Subject: FW: Planning Consultation on BR/126/19/DOC

Engineers Comments Regarding Condition 3- surface water drainage

Site Address: 65C Gravits Lane Bognor Regis PO21 5LN

Description of Works: Approval of matters reserved by condition imposed under BR/208/14/PL relating to condition 3-surface water drainage.

LOCATION PLAN
65C GRAVITS LANE BOGNOR REGIS

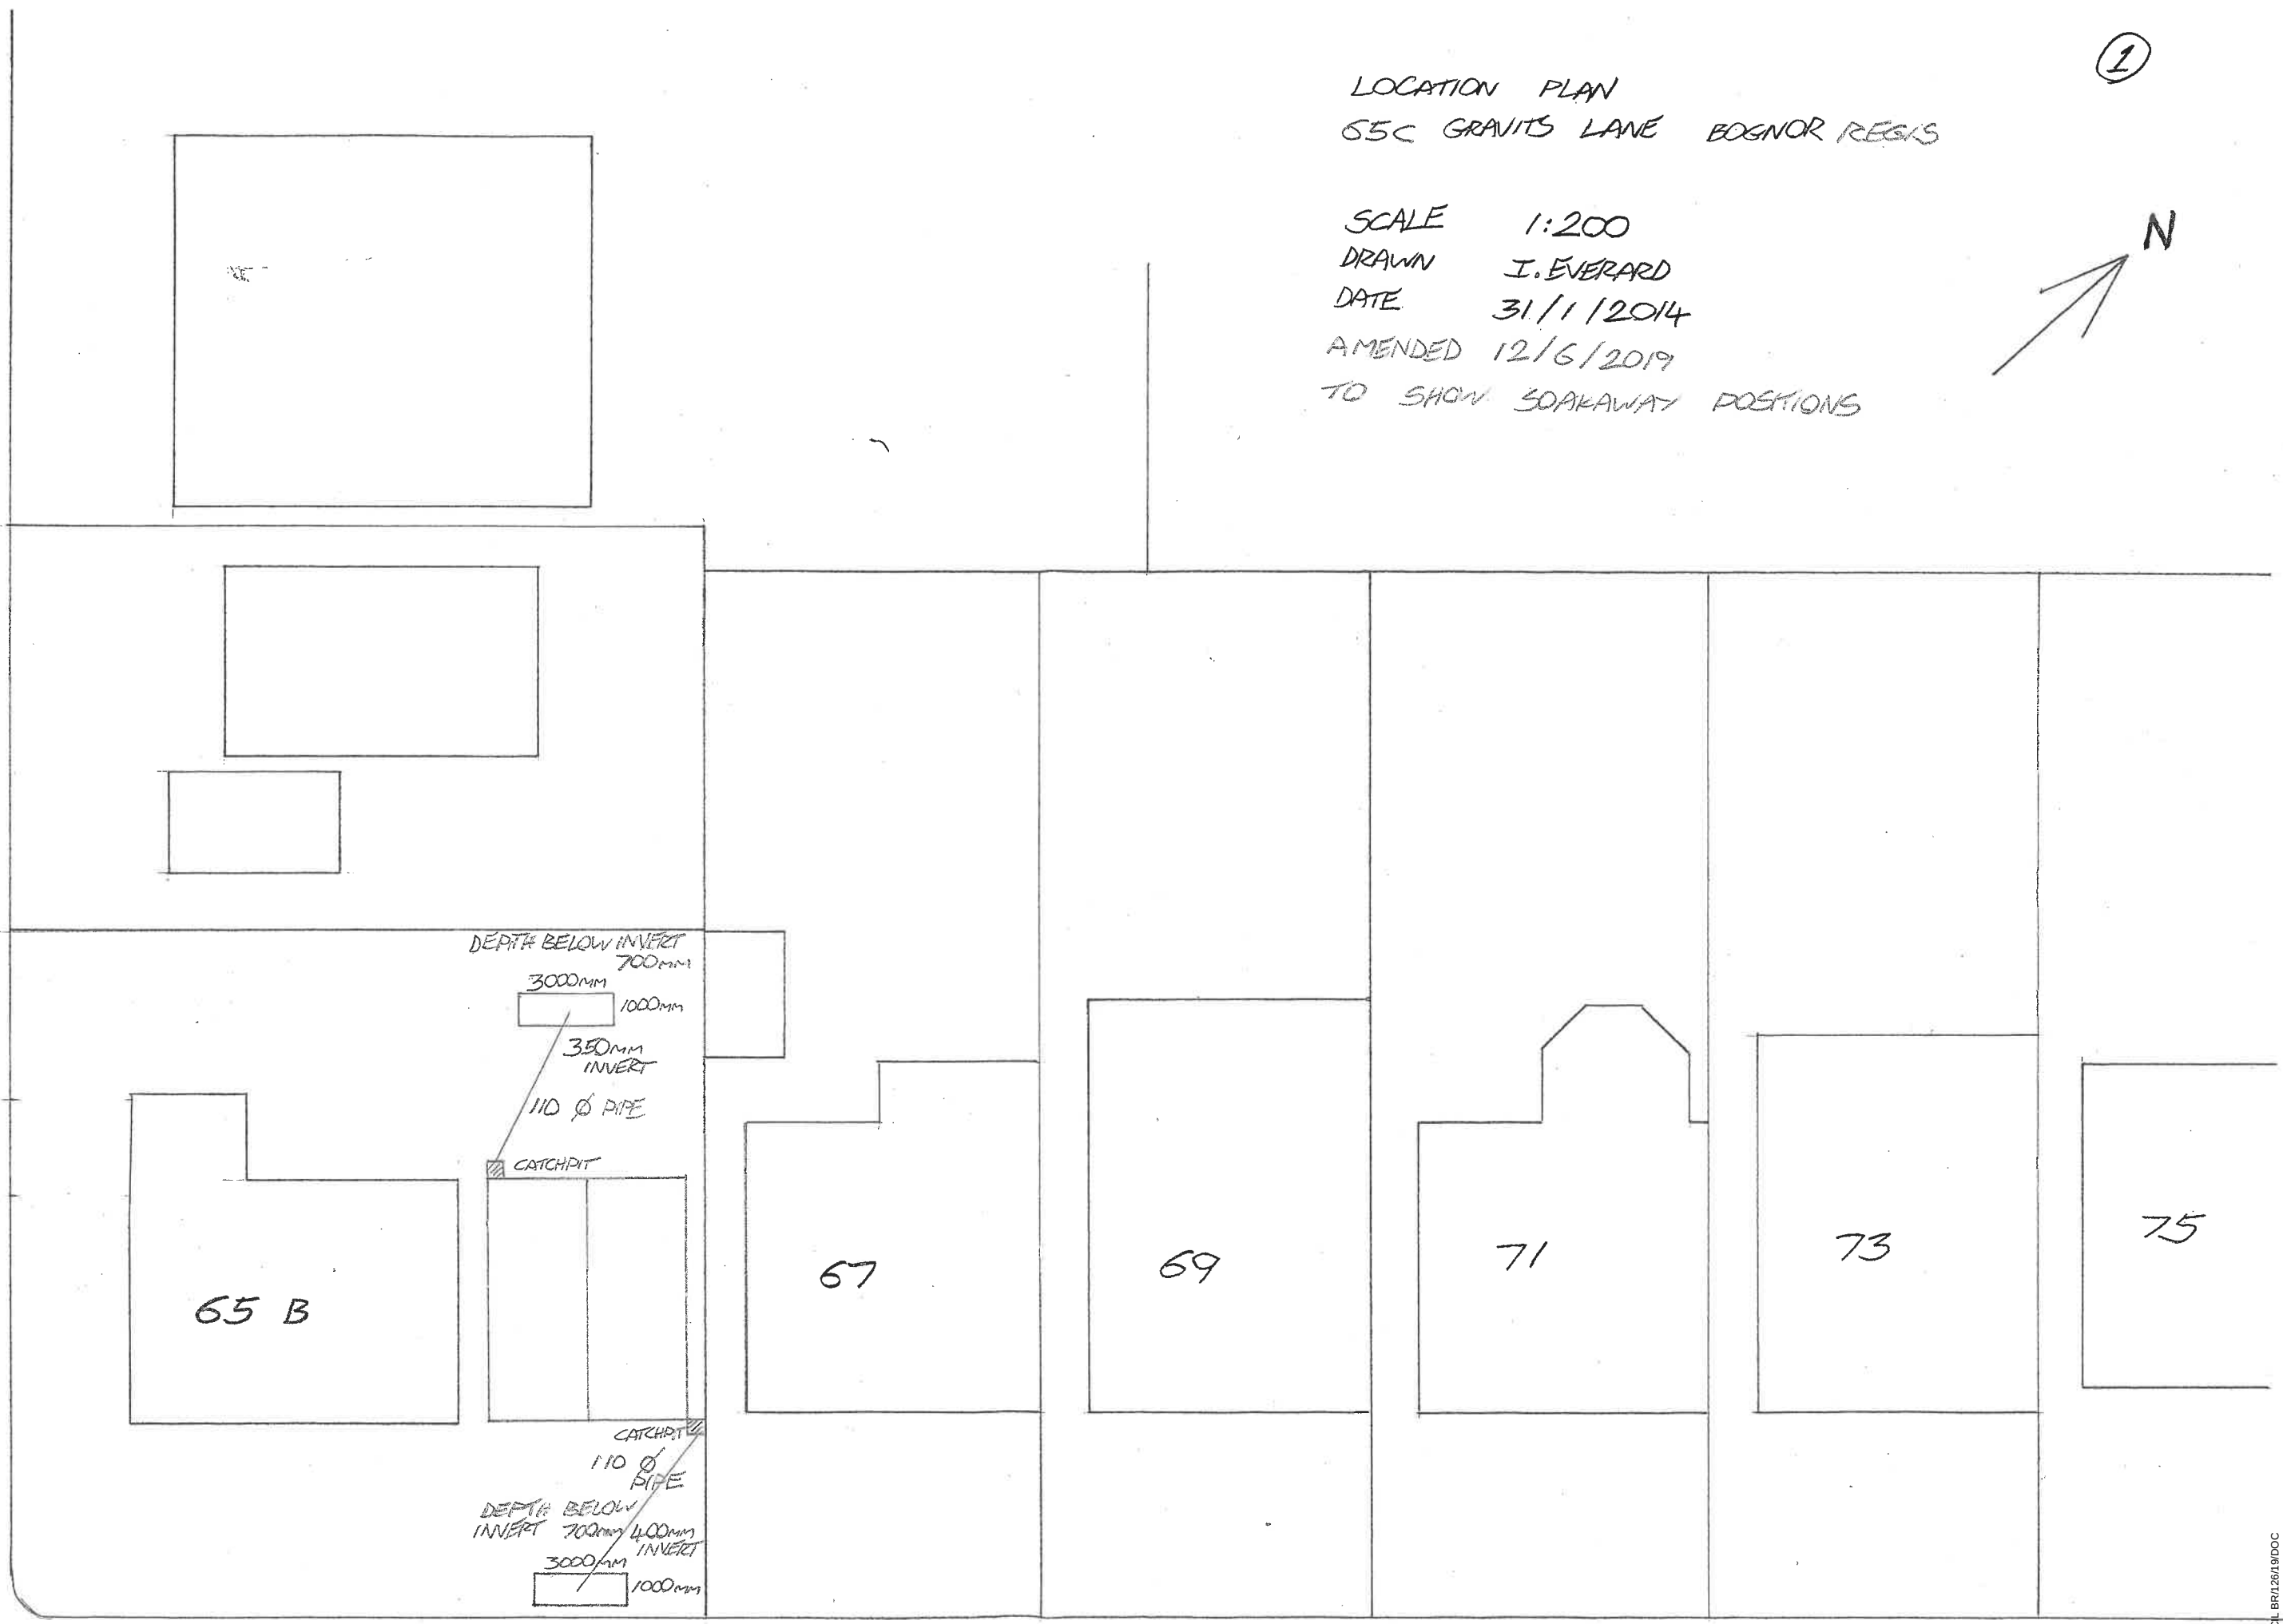
1. Insufficient storm durations have been detailed within calculations. Storm durations between 5 minutes and 24 hours should be examined.
2. Please can the applicant confirm when infiltration testing was completed, and to what depth.
3. Construction detail drawings are required.
4. Layout drawings need to be provided to scale and detailing proposed soakaway dimensions including invert and cover levels.
5. Catchpits need to be shown on plan upstream of all connections to soakaways.
